**CENTENNIAL MYUNA PTY LIMITED PA 10_0080 MODIFICATION
RECOMMENDED CONDITIONS OF APPROVAL**

The Environment Protection Authority (EPA) makes reference to your email and the supporting Environmental Assessment titled "*Environmental Assessment Myuna Colliery Section 75W Modification to Project Approval PA 10_0080*" dated November 2014 and prepared by Centennial Coal Company Limited (EA).

ENVIRONMENT PROTECTION AUTHORITY – REVIEW OF ENVIRONMENTAL ASSESSMENT AND RECOMMENDED CONDITIONS OF APPROVAL 10_0080 MODIFICATION CENTENNIAL MYUNA PTY LIMITED

Figure 4 Comparison of Wind Roses – 9am and 3pm – Cooranbong (Lake Macquarie AWS)

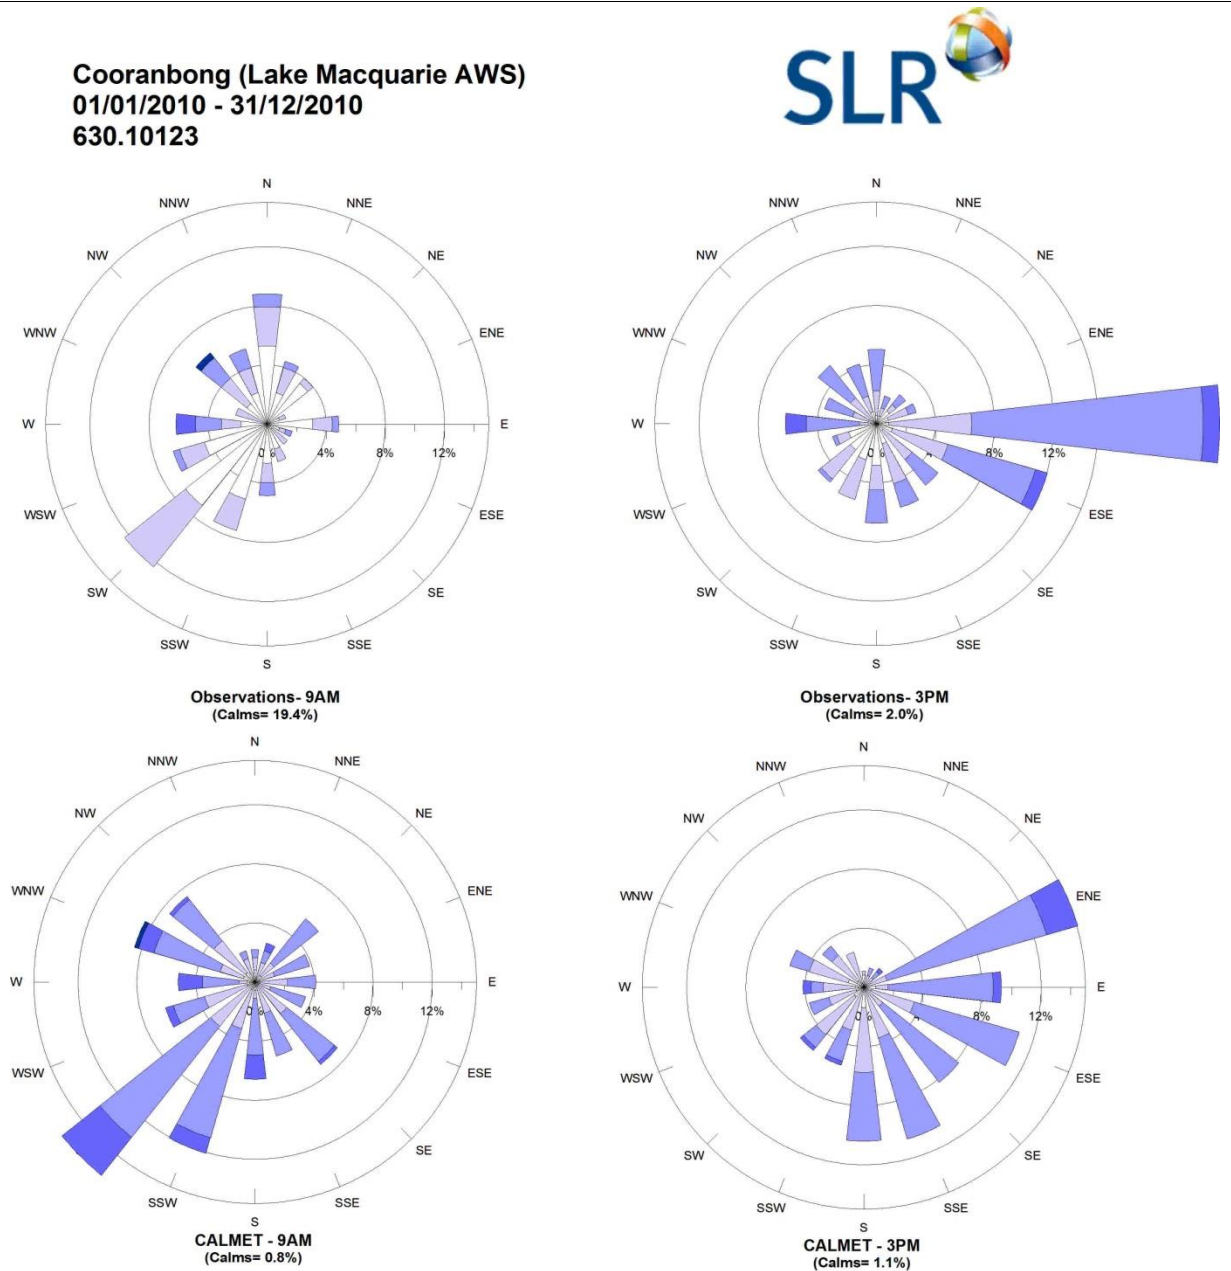
Meteorological data has not been demonstrated to be site representative

The AQIA has utilised a synthetic prognostic meteorological dataset utilising MM5 and CALMET for inclusion within the quantitative component of the assessment. The EPA notes that the meteorological data utilised to represent the site contains inconsistencies with the Myuna Colliery Extension Project (Heggies, 2010)*, specifically noting:

- Annual representation of calms of 0.3 %, as compared with 6% within the assessment provided for the Extension Project; and
- Annual representation of F class stability of 13 %, as compared with 25 % within the assessment provided for the Extension Project.

In accordance with the Section 9.4.2 of the Approved Methods, meteorological data must be demonstrated to be site representative.
